SOLBERG PIT - SITE PLAN

SECTION 21, TOWNSHIP 13 SOUTH, RANGE 64 WEST
OF THE 6TH P.M., EL PASO COUNTY, COLORADO

SOLBERG PIT - SITE PLAN

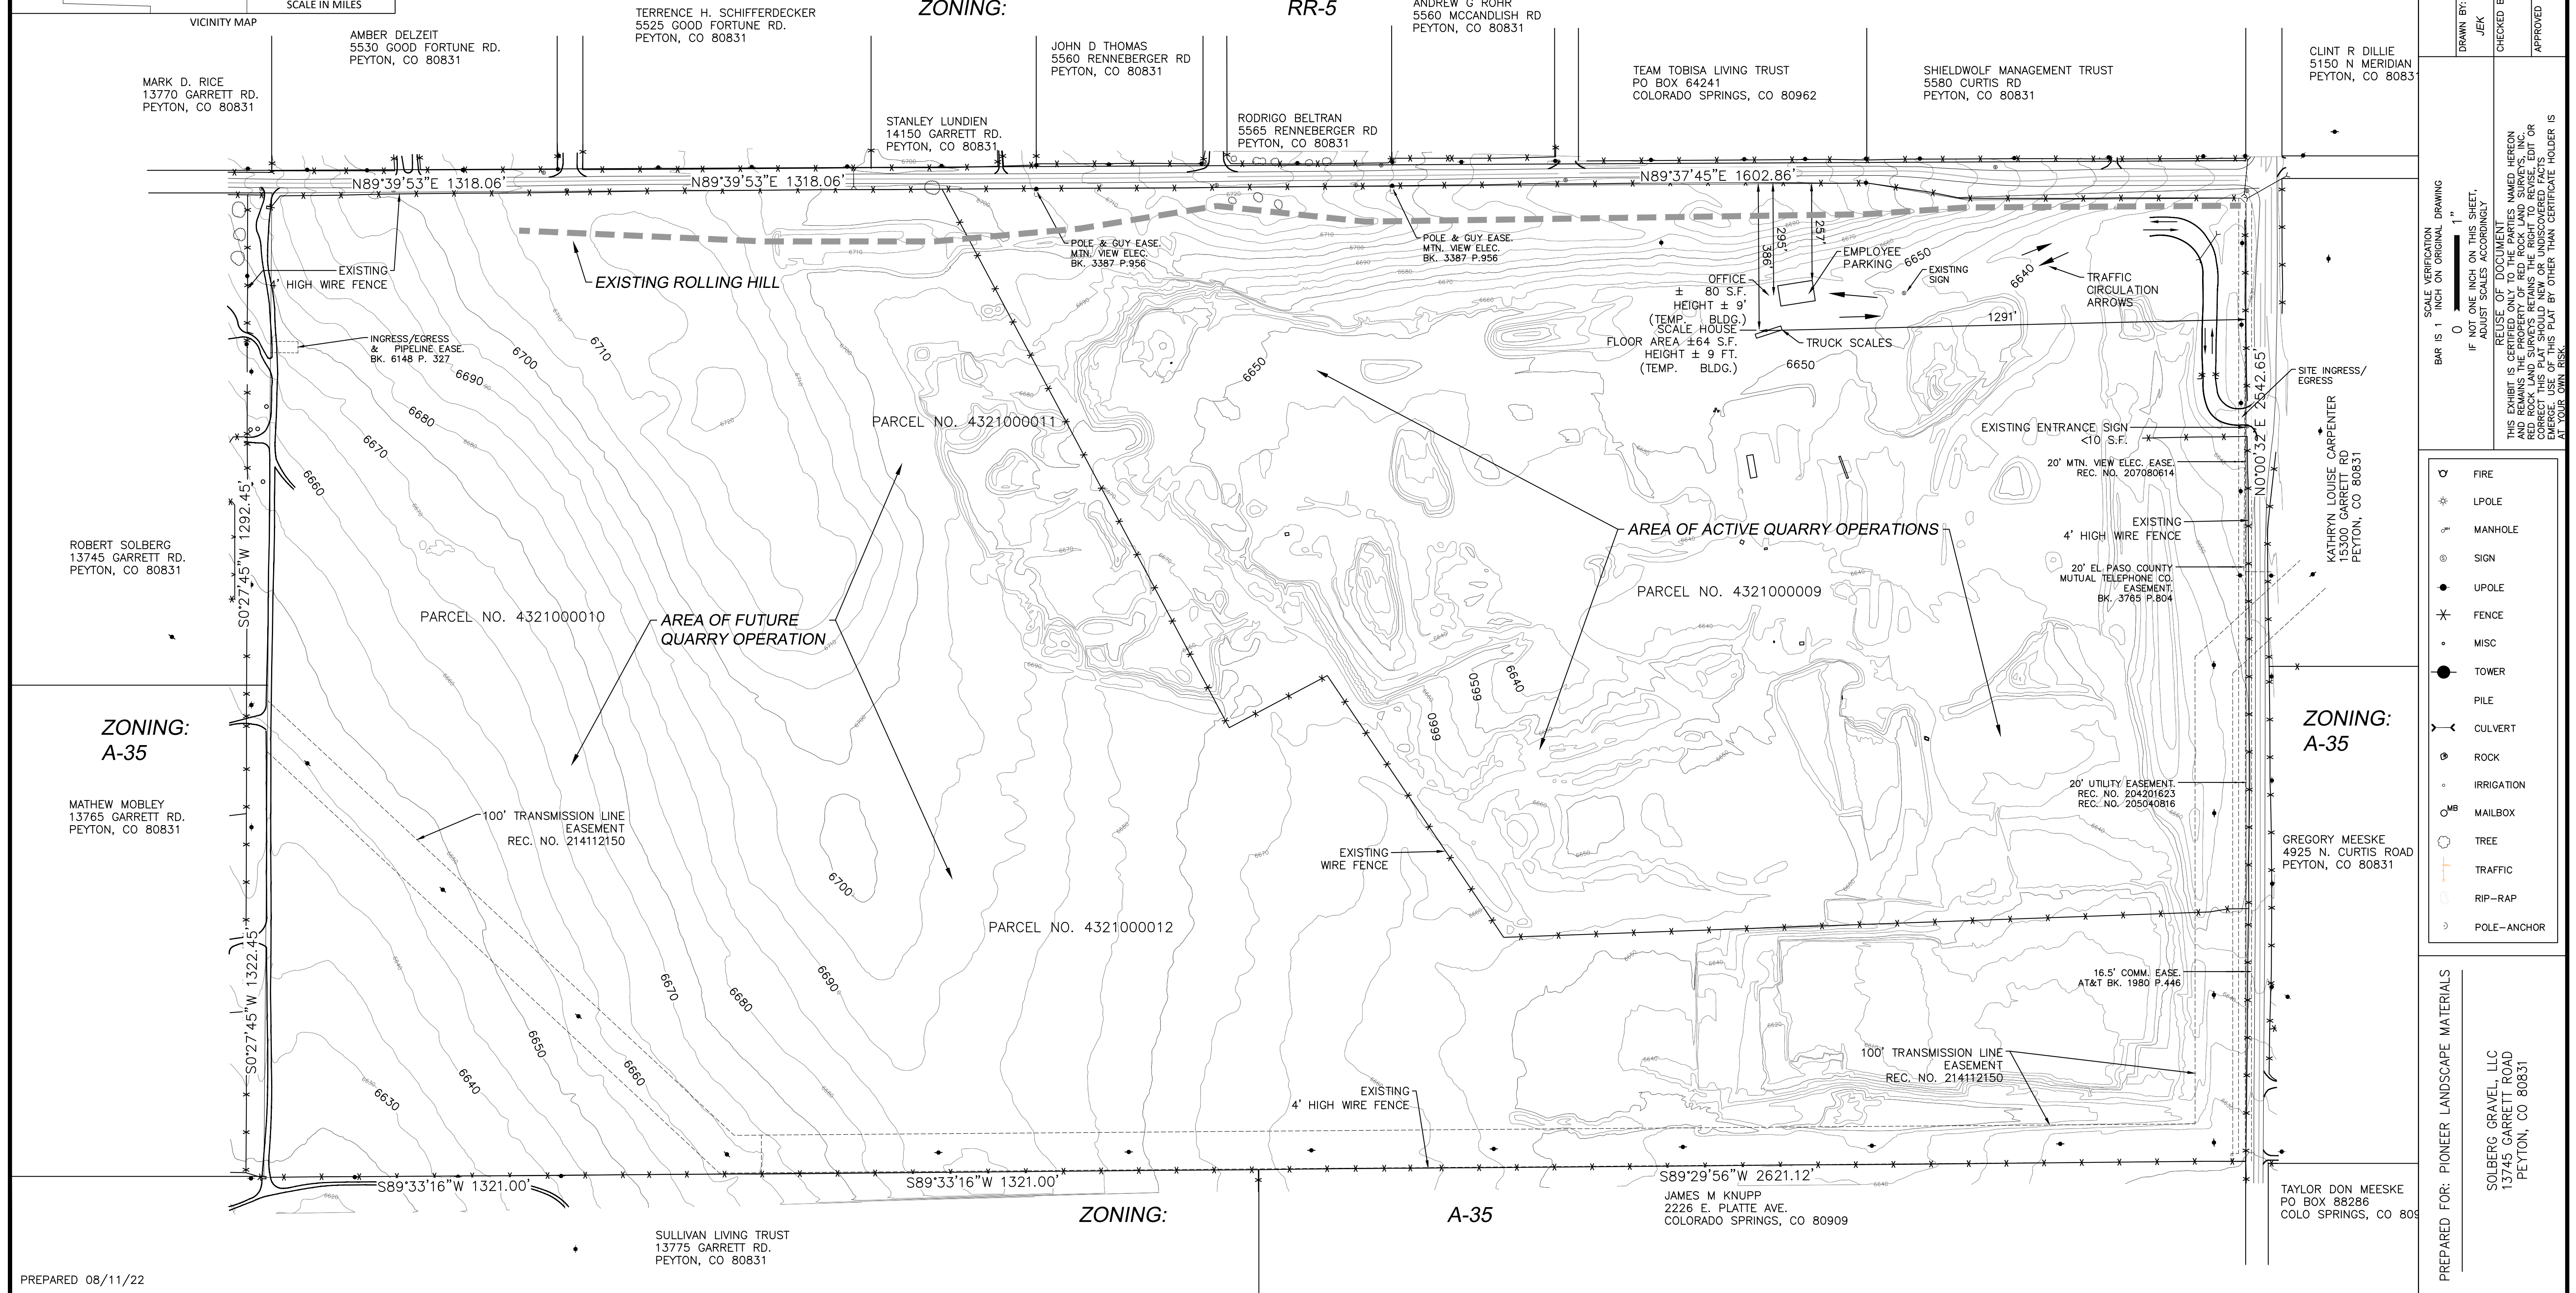
This note appears to be in conflict with the information depicted on the plan, which shows berms.

Remove this. Open space is not required component of this type of application and is not applicable here. However, landscaping will be required per the other comments so a calculation of the total site landscaping will be needed at the site development plan stage.

V1 review comment unaddressed:
 Include the heights of fences, berms, etc.
 A specific landscape plan is not required with a special use application; however, we will need to know the heights of these improvements in order to determine the feasibility of landscaping / screening on the property.
